From: Raymond Cole [REDACTED]
Sent: 05 February 2018 19:28
To: Simon Davis
Cc: Stephen Fletcher; Michael Gadd; Stephen Bennett
Subject: Land at Kings Close, Yapton - Reserved Matters Application - Y/74/17/RES - Message 2 of 2

A full list of amendments for the house plans and elevations is set out below:

PLOT 1 HOUSE PLANS

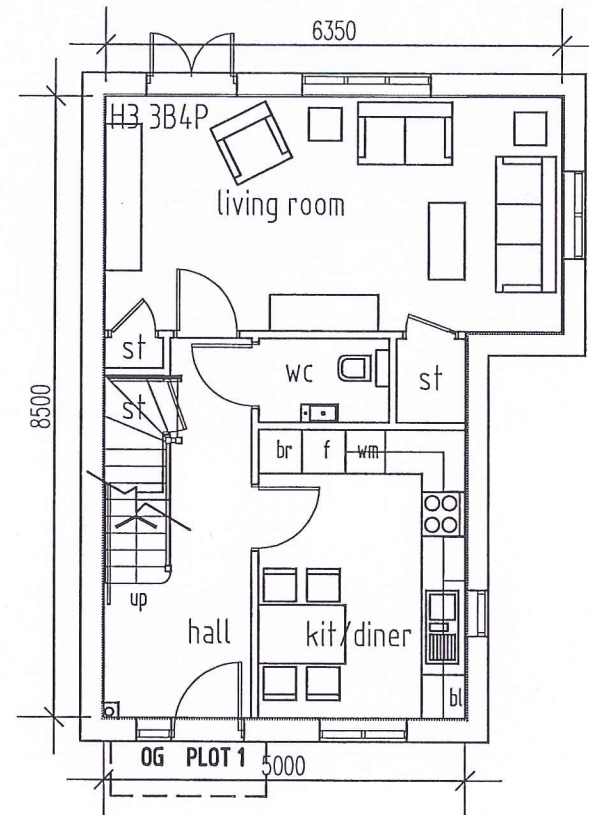
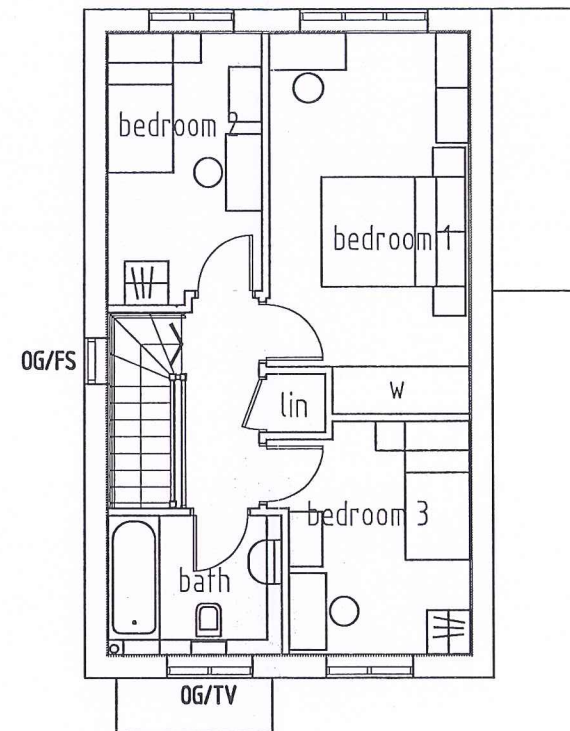
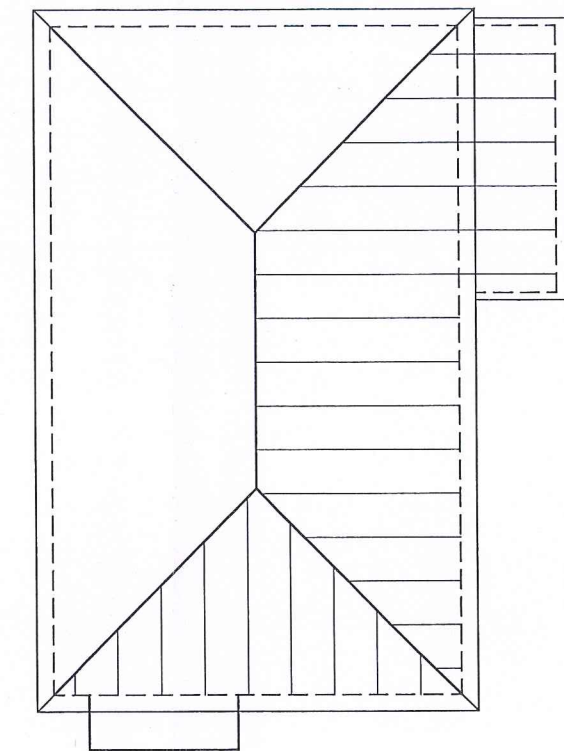
- The stair window on the southern elevation has been noted as obscure glazed and fixed shut in consideration of the distance to Kingshaven.
- The east elevation first floor bathroom window is noted as obscure glazed top vent opening and the cill has been lifted to better accommodate internal fittings.

PLOTS 2- 4 HOUSE PLANS - SHEET 1

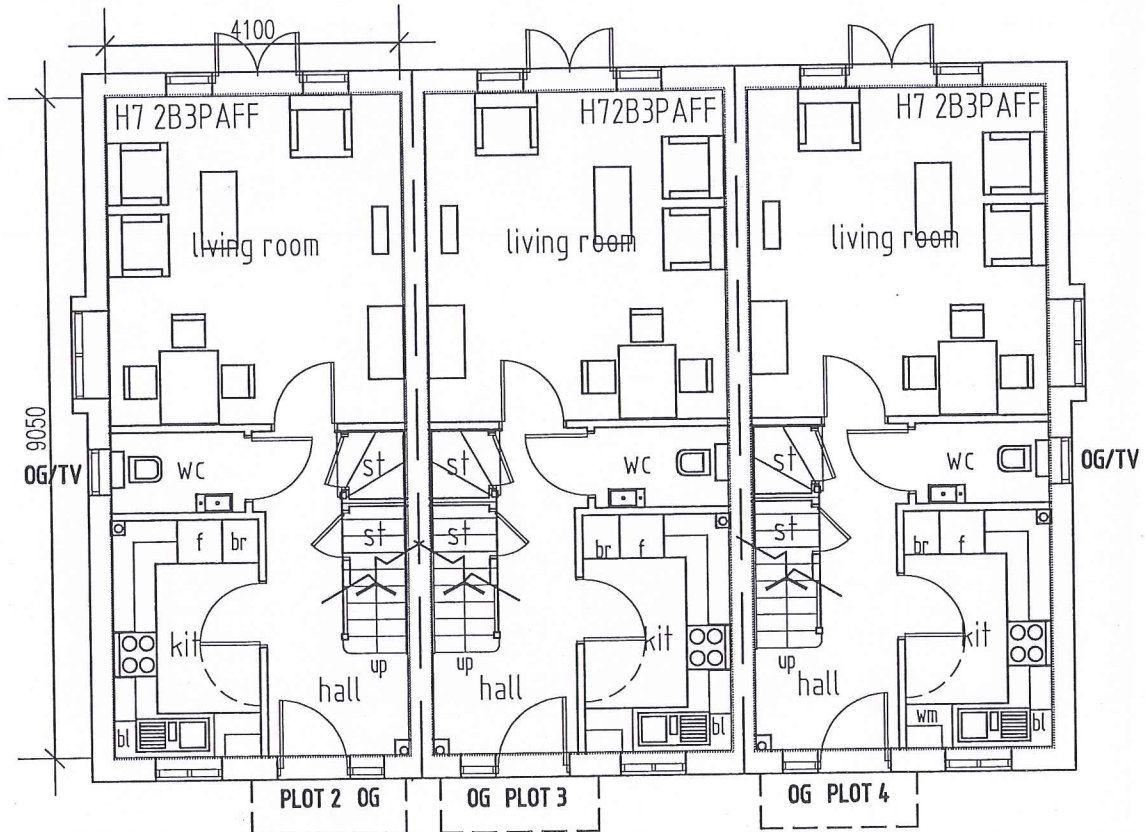
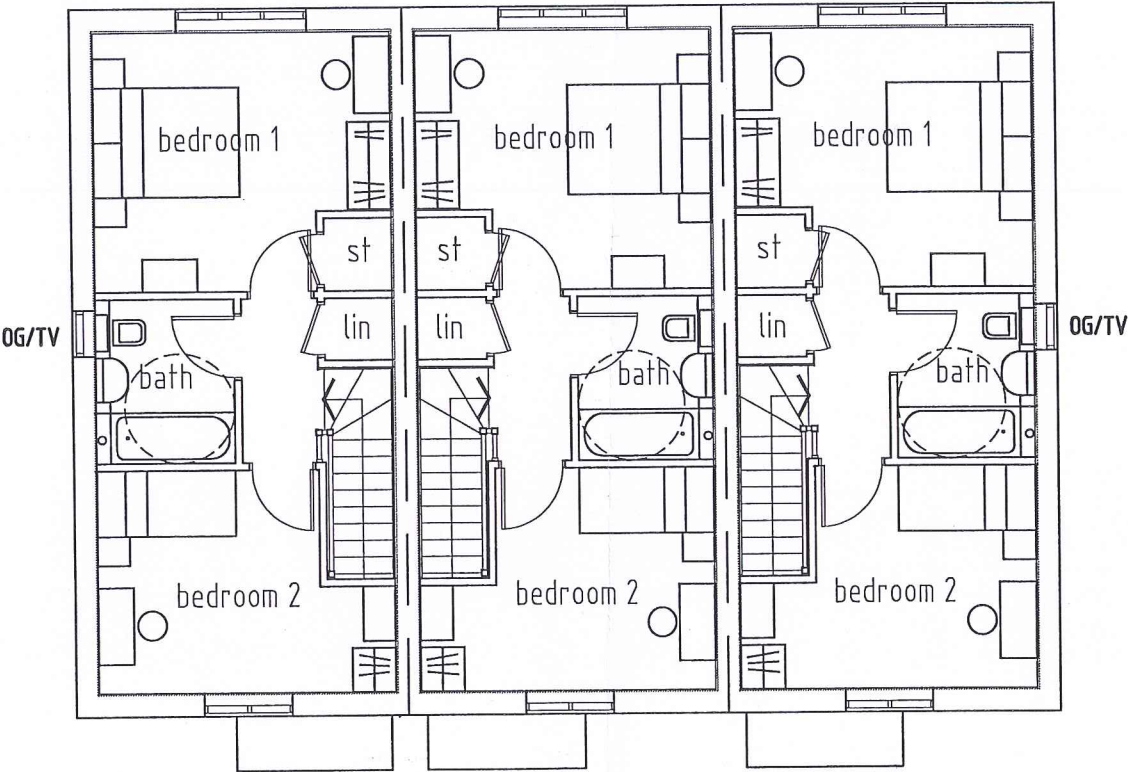
- The ground floor WC and first floor bathroom windows in the north elevation of plot 2 and the south elevation of plot 4 have been noted as obscure glazed top vent opening.

# PLOT 13 HOUSE PLANS

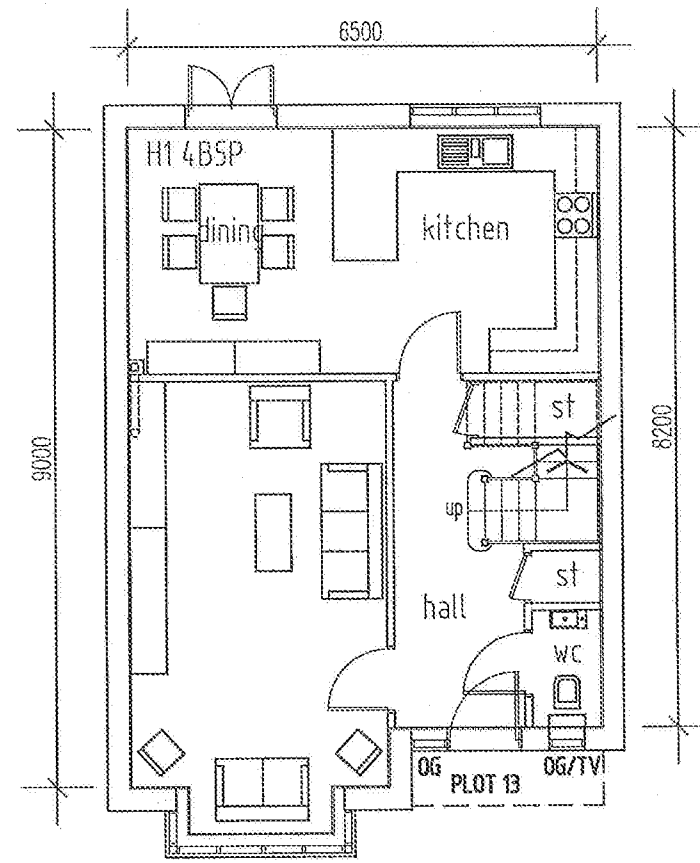
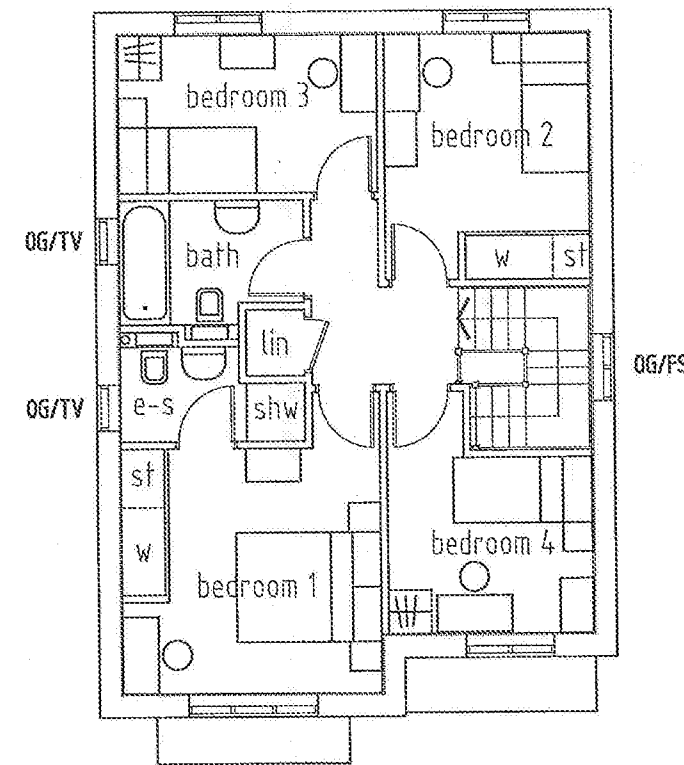
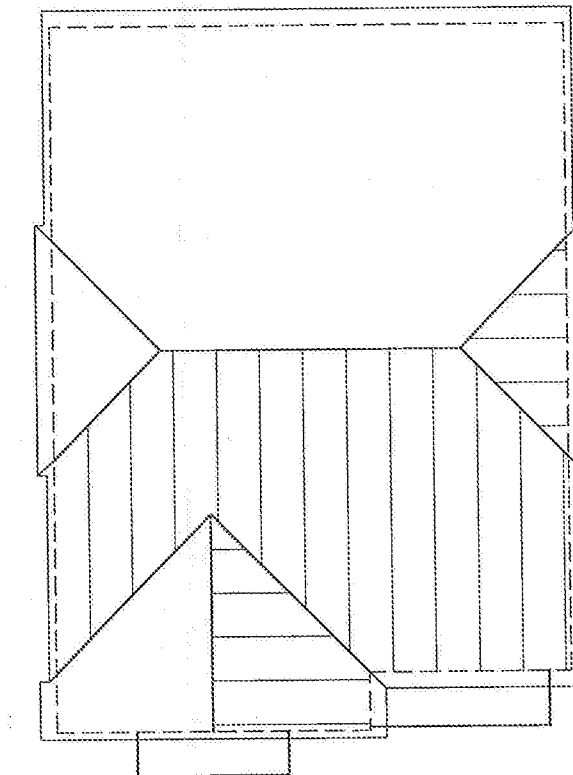
- The ground floor east elevation WC window has been noted as obscure glazed top vent opening.
- The stair window on the north elevation in common with the other stair windows on site has been noted as obscure glazed and fixed shut.
- The first floor south elevation bathroom and en suite windows have been noted as obscure glazed top vent opening.

PLOTS 16 - 18 HOUSE PLANS - SHEET 2

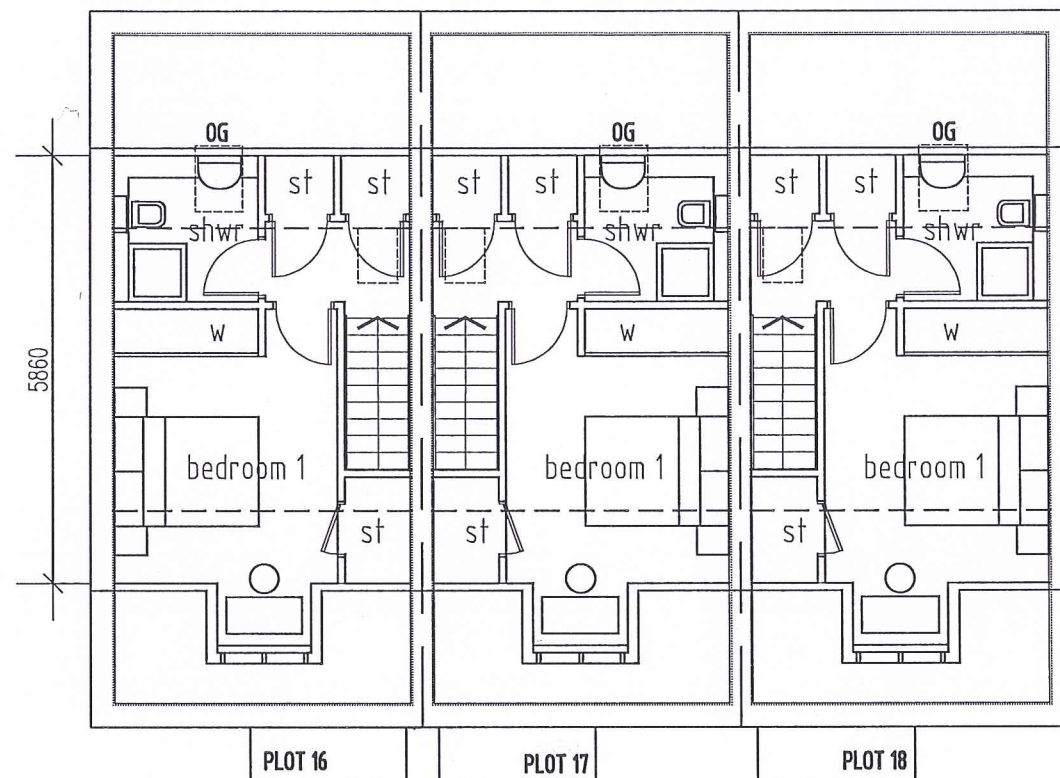
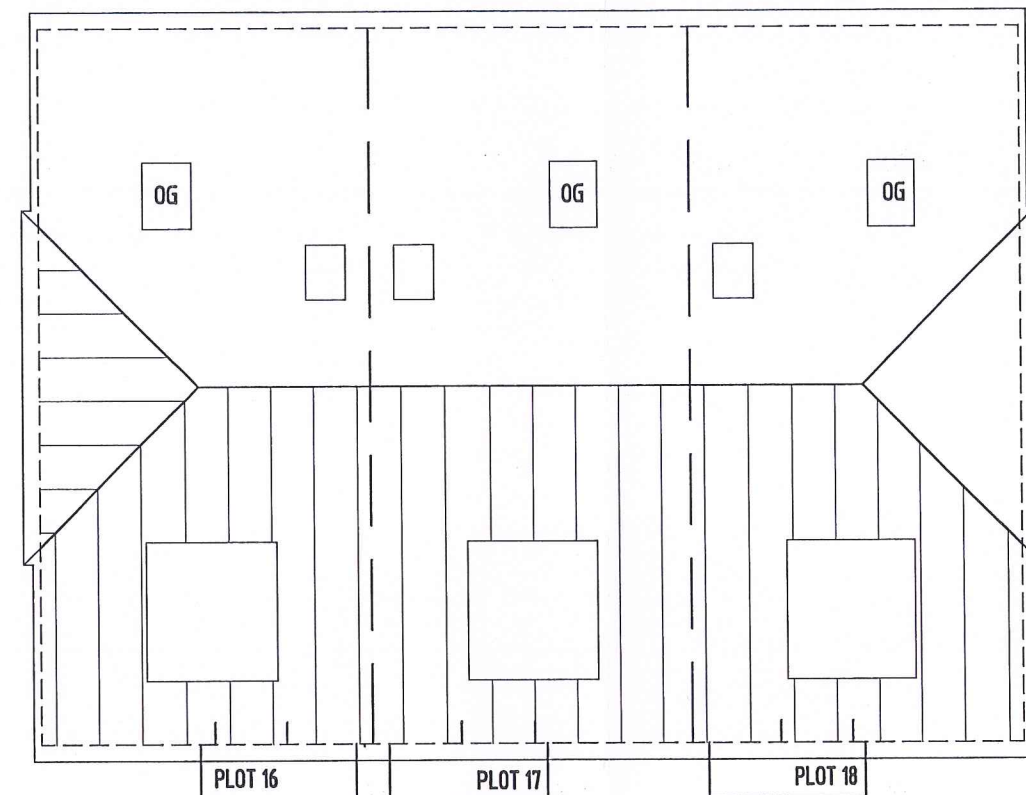
- The ground floor windows of the WC's in the north elevation have been noted as obscure glazed top vent opening
- The ground floor dining area window in the west elevation of plot 18 has been noted as fixed shut to remove the risk of external collision with an open window whilst using the side access. The first floor bathroom window above has been noted as obscure glazed top vent opening.
- The second floor south elevation shower room roof windows of plots 16-18 have been noted as obscure glazed.
- The ground floor dining area window in the east elevation of plot 16 has been noted as obscure glazed and fixed shut to remove the risk of external collision with an open window and also provide privacy onto the common rear access. The first floor bathroom window above has been noted as obscure glazed top vent opening to protect the interface with plots 14-15.

PLOT 14 - 15 ELEVATIONS - SCALE 1:100
Drawing prepared for approval of reserved matters following Outline Planning Approval Y/22/14

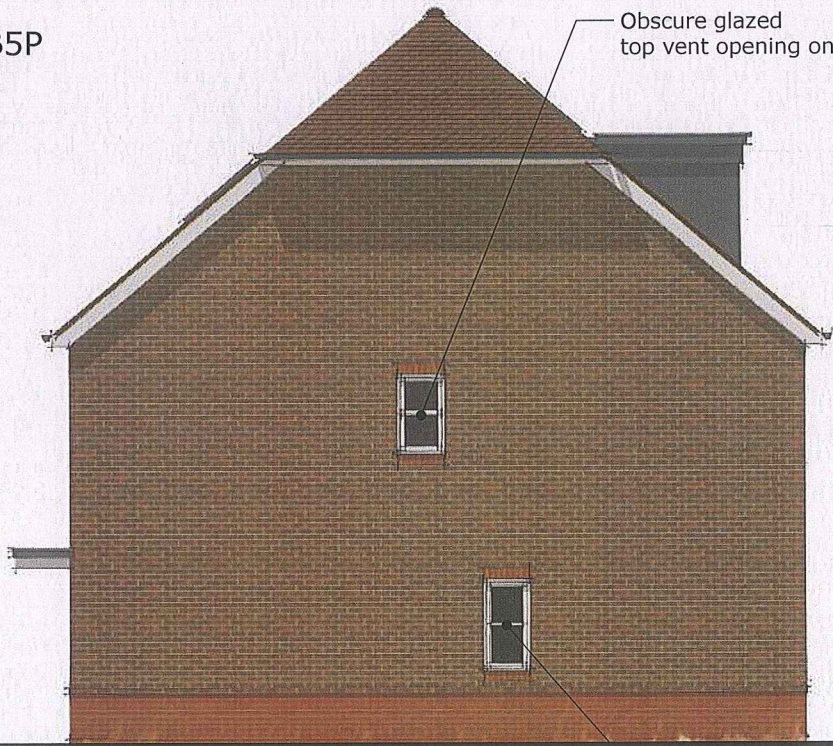
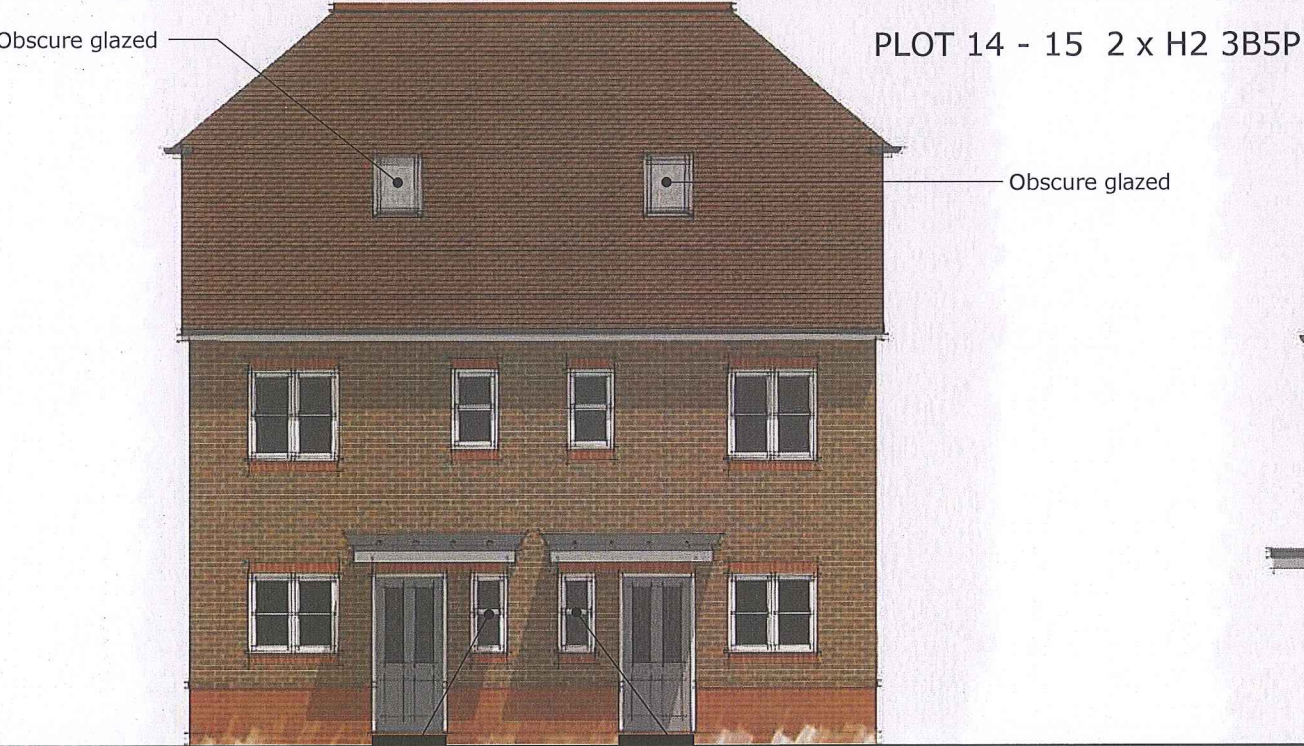
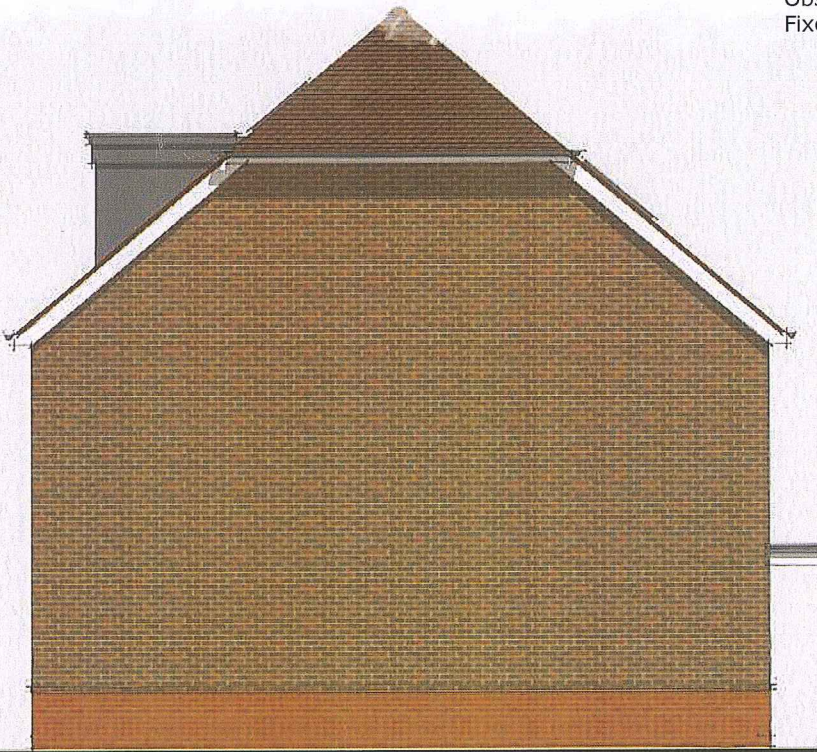
- The ground floor windows of the WC's in the east elevation have been noted as obscure glazed top vent opening and the second floor ensuite roof windows above have been noted as obscure glazed
- The ground floor dining area window in the north elevation of plot 15 has been noted as obscure glazed and fixed shut to remove the risk of external collision with an open window and also provide privacy onto the adjacent Kings Mews common access. The first floor bathroom window above has been noted as obscure glazed top vent opening.
- The small flank windows on the south elevation of plot 14 have been removed in consideration of unprotected areas at boundaries.
